Application for a [REDACTED] material amendment following a grant of planning permission.
Town and Country Planning Act 1990

ERECTION OF 2 NO DWELLINGS
PLOTS 5 & 6, SITE OFF RIGGONS GRAVE, STAINCROSS, BARNESLEY
S75 6LZ

8. Non-Material Amendment(s) Sought

DRWG. NO. 2010/011/03A

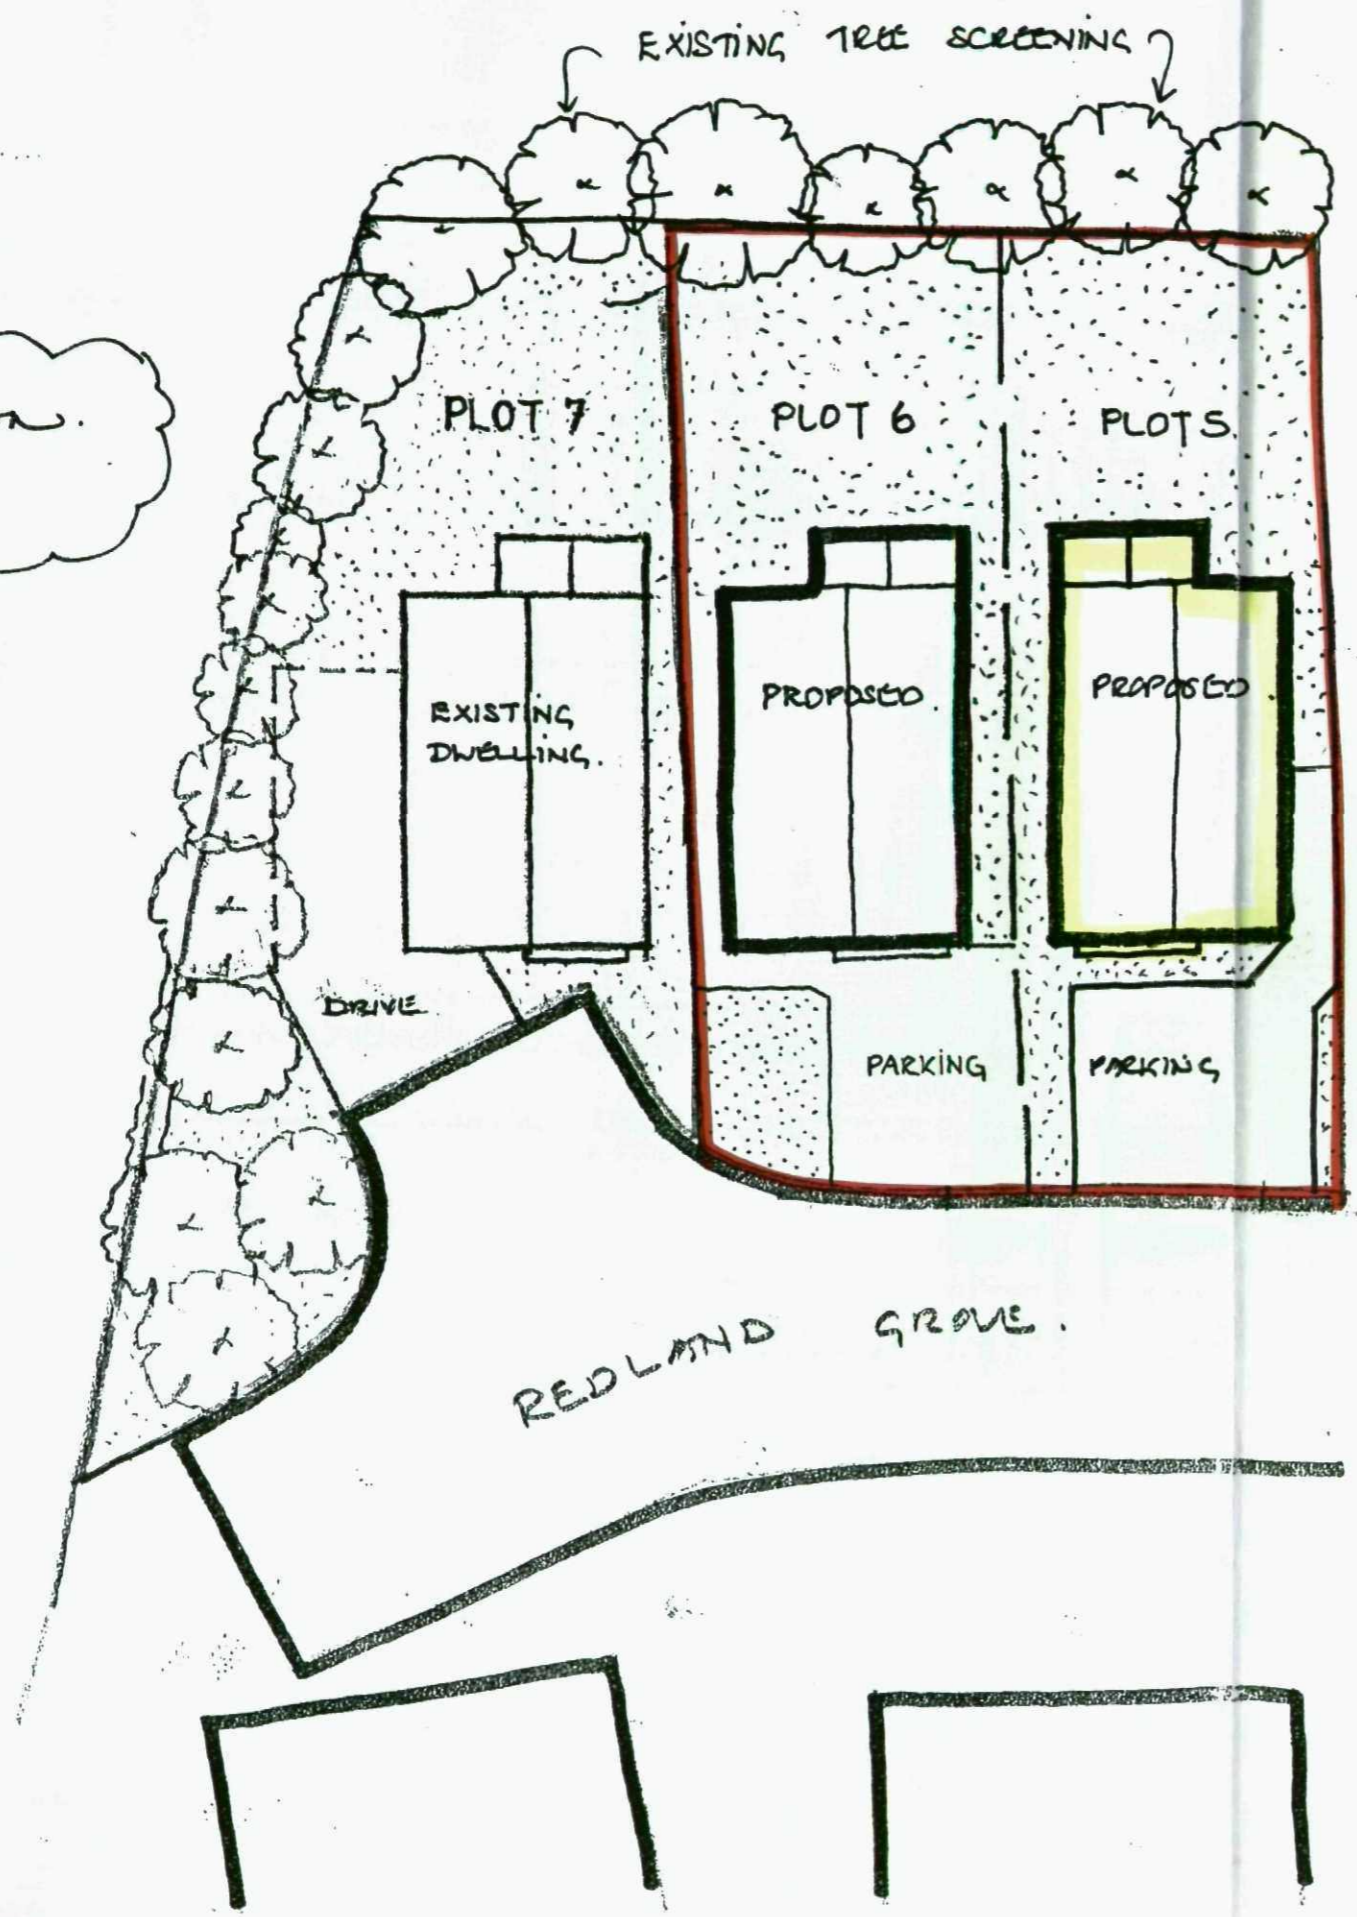
CLIENT WISHES TO 'HAND' PLOT 5.
FOOTPRINTING SIZE & LAYOUT REMAINS UNCHANGED.

CLIENT (APPLICANT) WISHES TO 'HAND' PLOTS

SITE LAYOUT PLAN REF 2010/011/03A
